A303 Sparkford to Ilchester Dualling Scheme TR010036

8.1 Draft Statement of Common Ground with Environment Agency

STATEMENT OF COMMON GROUND

Version	Date	Status of Version
C01	July 2018	Application Issue
C02	December 2018	Working draft – for Environment Agency to review
Rev A	January 2019	Submission for Deadline 2

2.11 Outline Drainage Works Plans

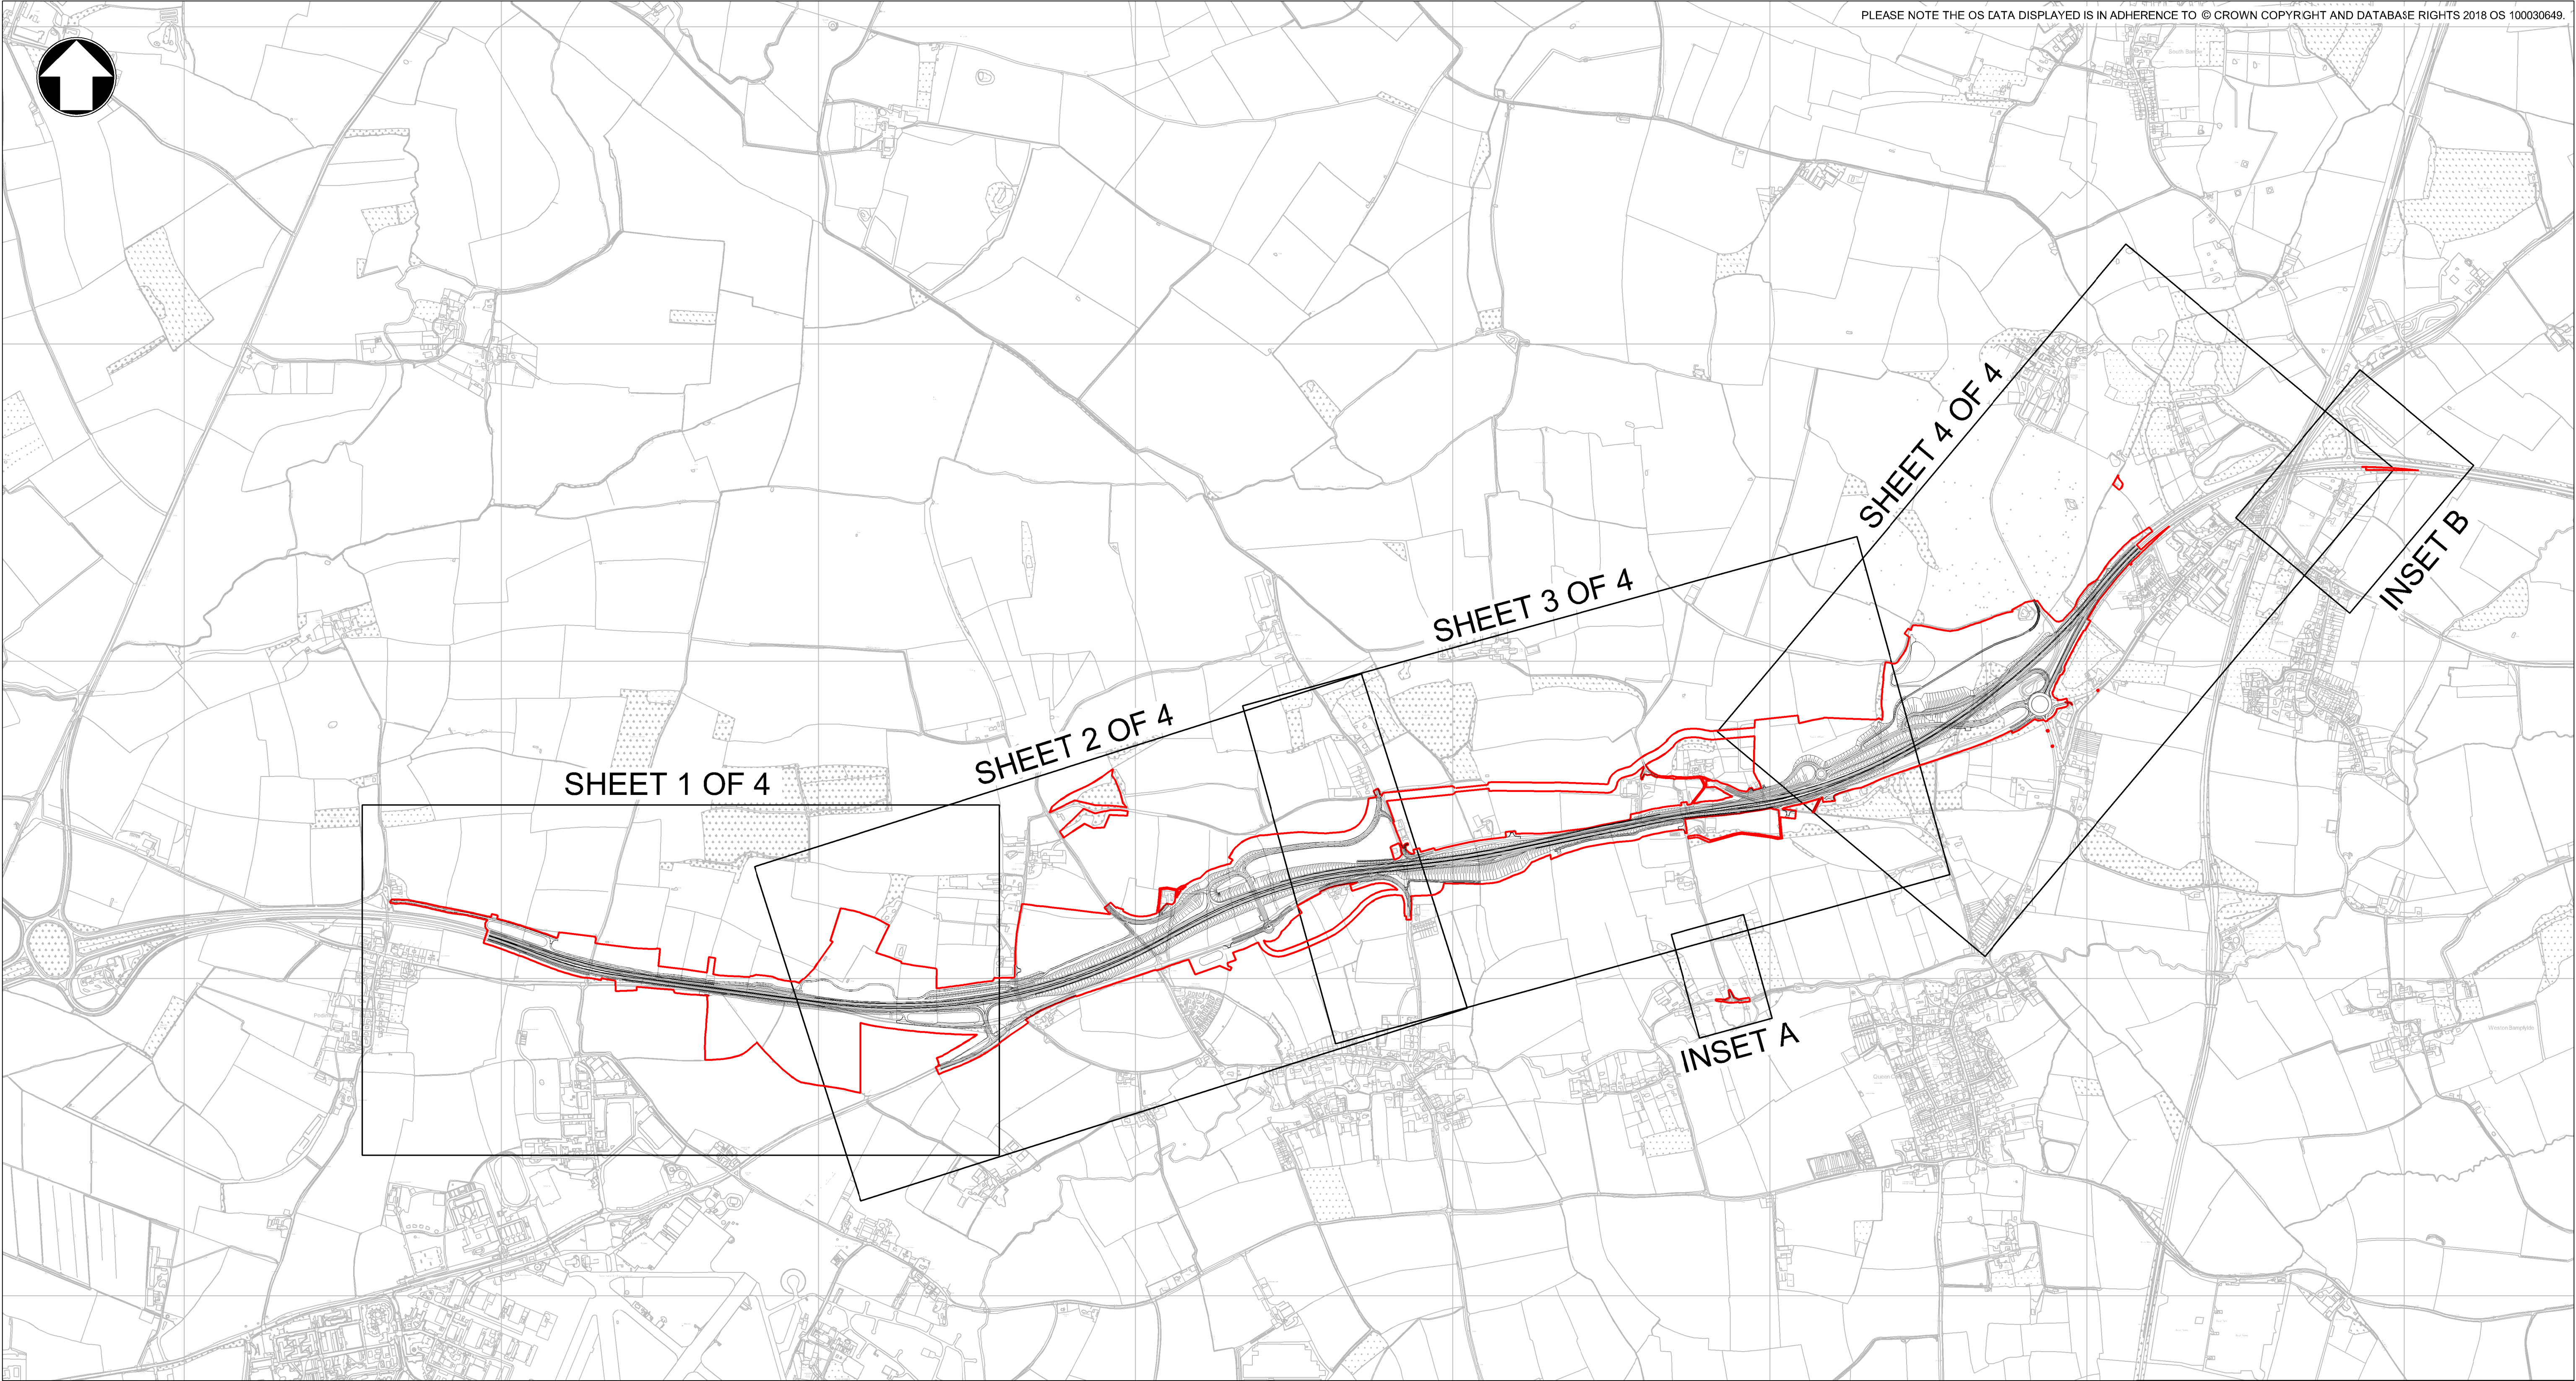
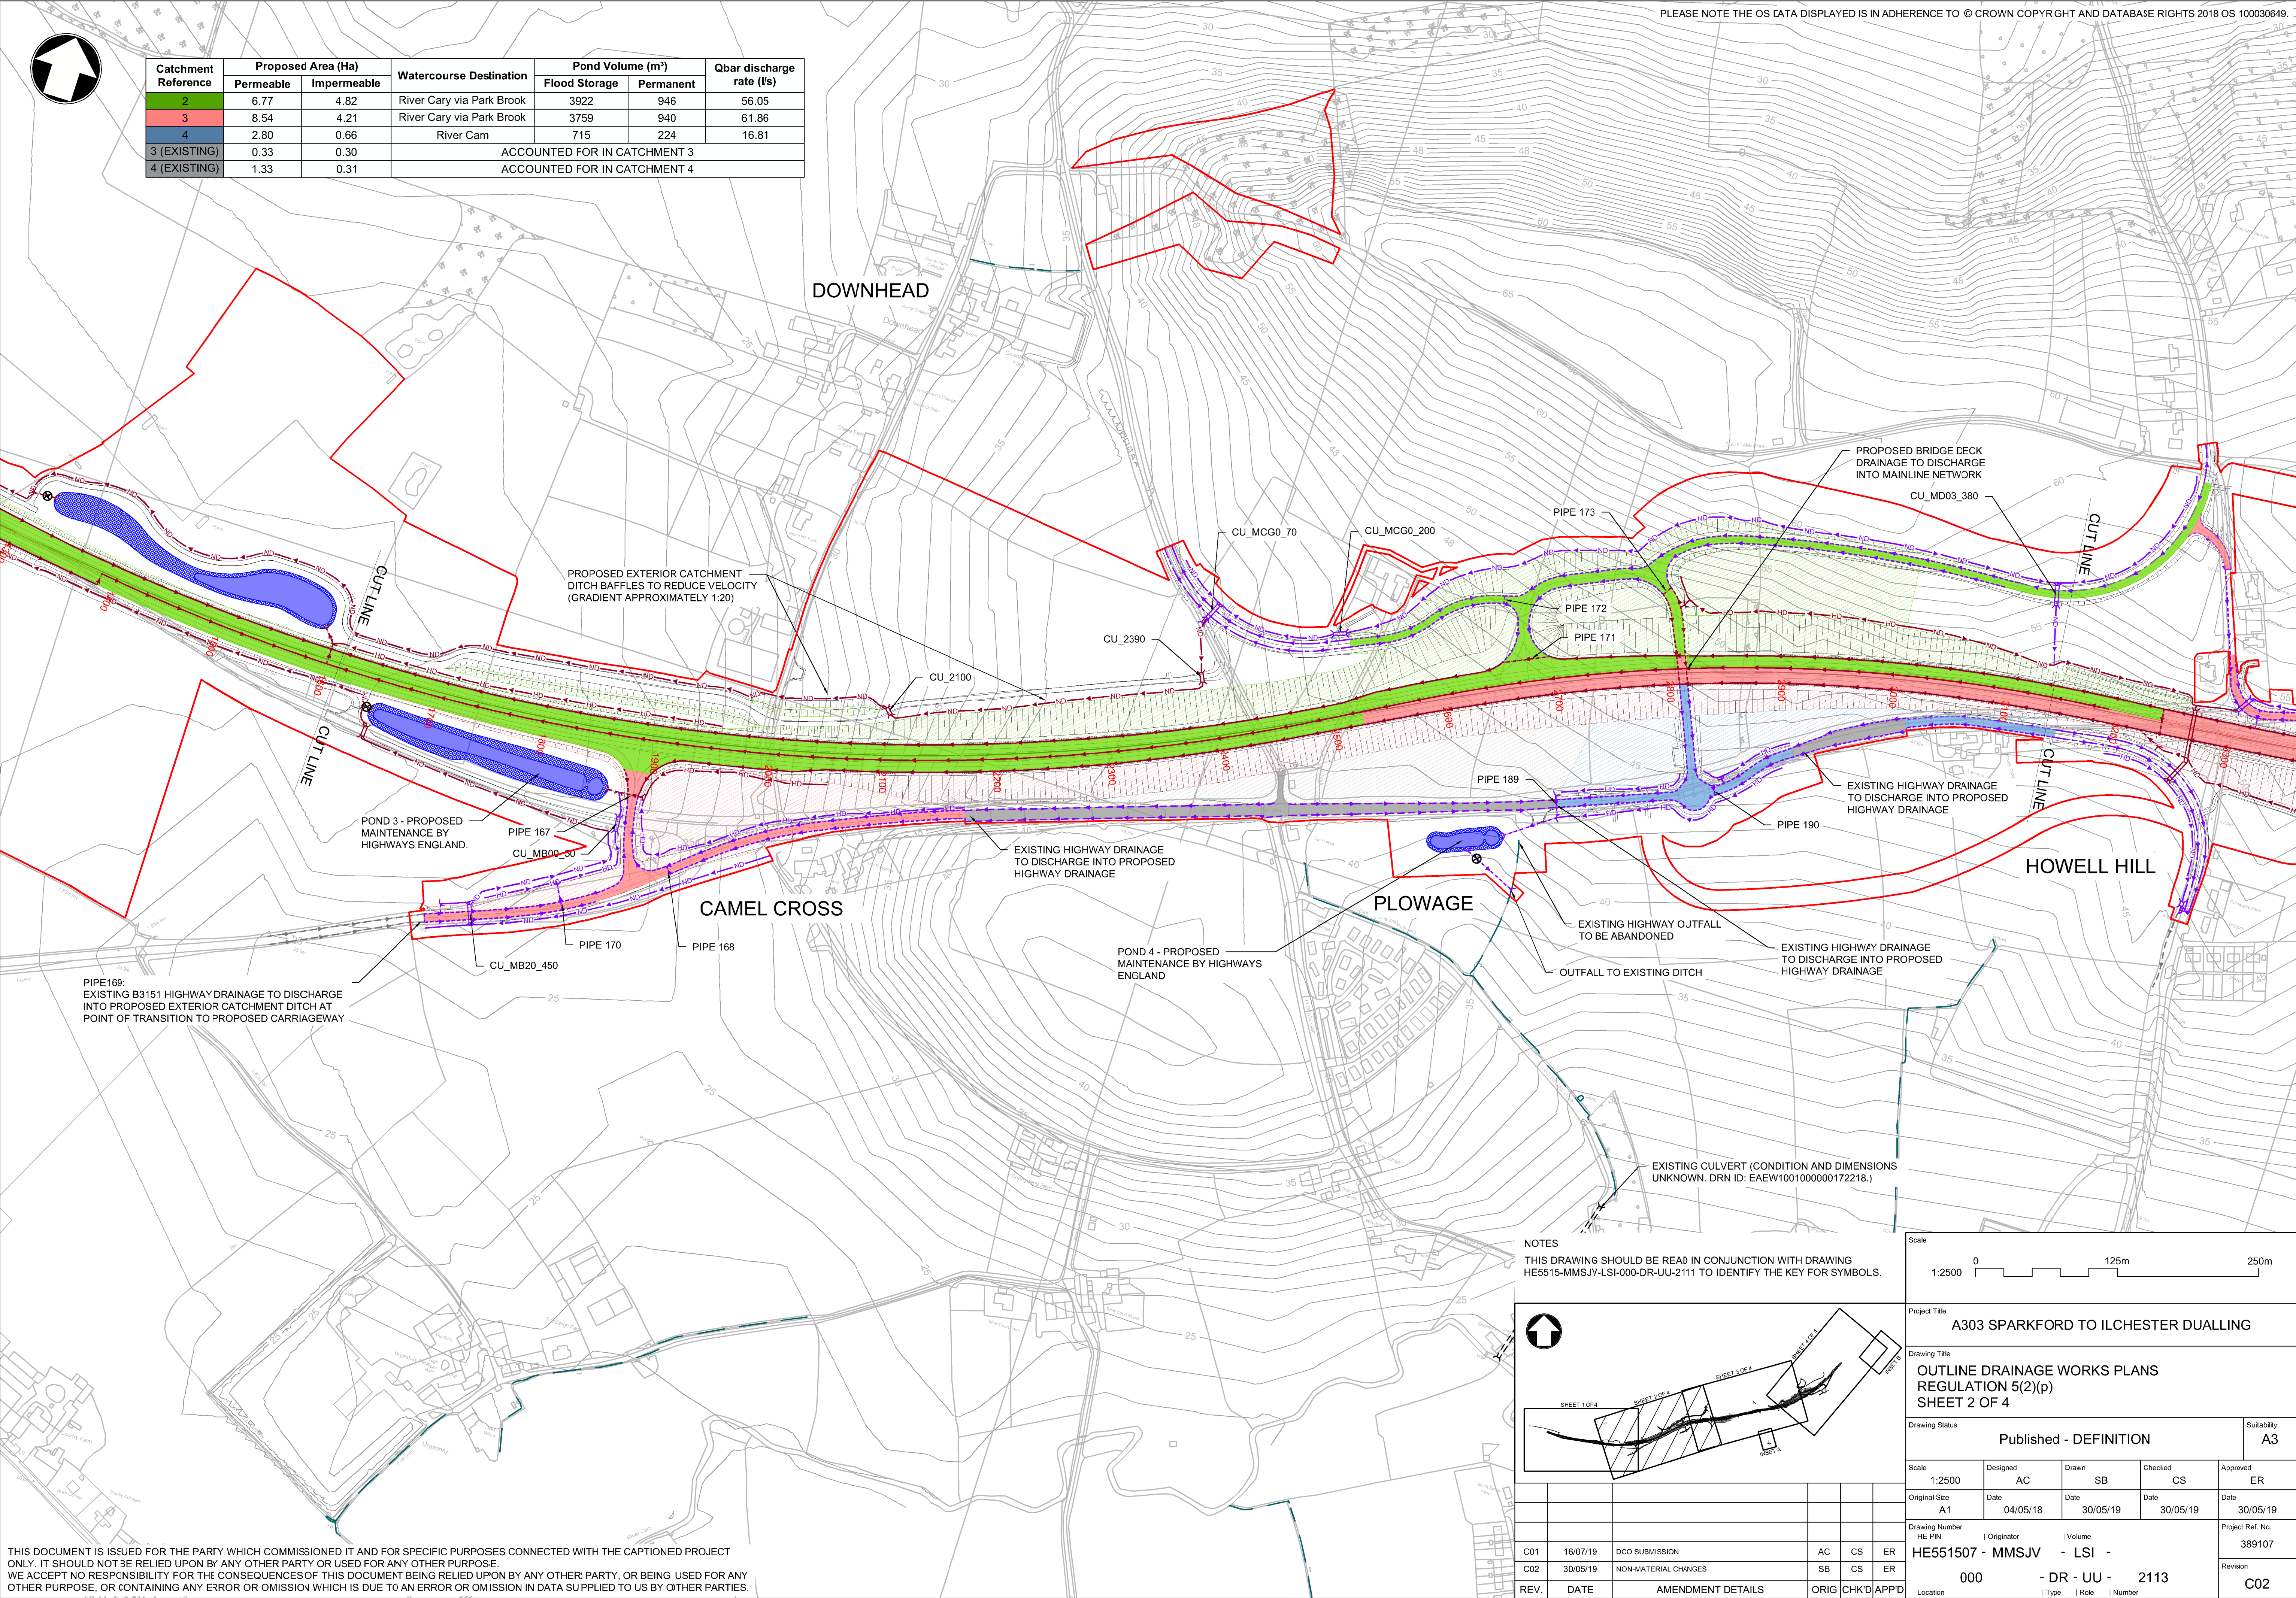
Topic	Sub-section	Environment Agency comment	Highways England response	Status
			Attenuation feature discharge rates and volumes shown in Outline Drainage Works Plans (TR010036/APP/2.11).	
		Confirmation is sought that the proposed design will control the overall volume, as well as the overall rate of runoff with sufficient attenuation provided.	Attenuation has been provided, with discharge limited to 1% annual exceedance probability (1 in 100-year event) plus 40% to account for the effects of climate change (Flood risk assessments: climate change allowances, Environment Agency), to no greater than the undeveloped rate of runoff, determined by the calculation of the mean annual peak rate of runoff for a greenfield site (Qbar). Preliminary design discharge rates and volumes shown in Outline Drainage Works Plans (document reference TR010036/APP/2.11).	AGREED <i>(see letter contained in Appendix A)</i>
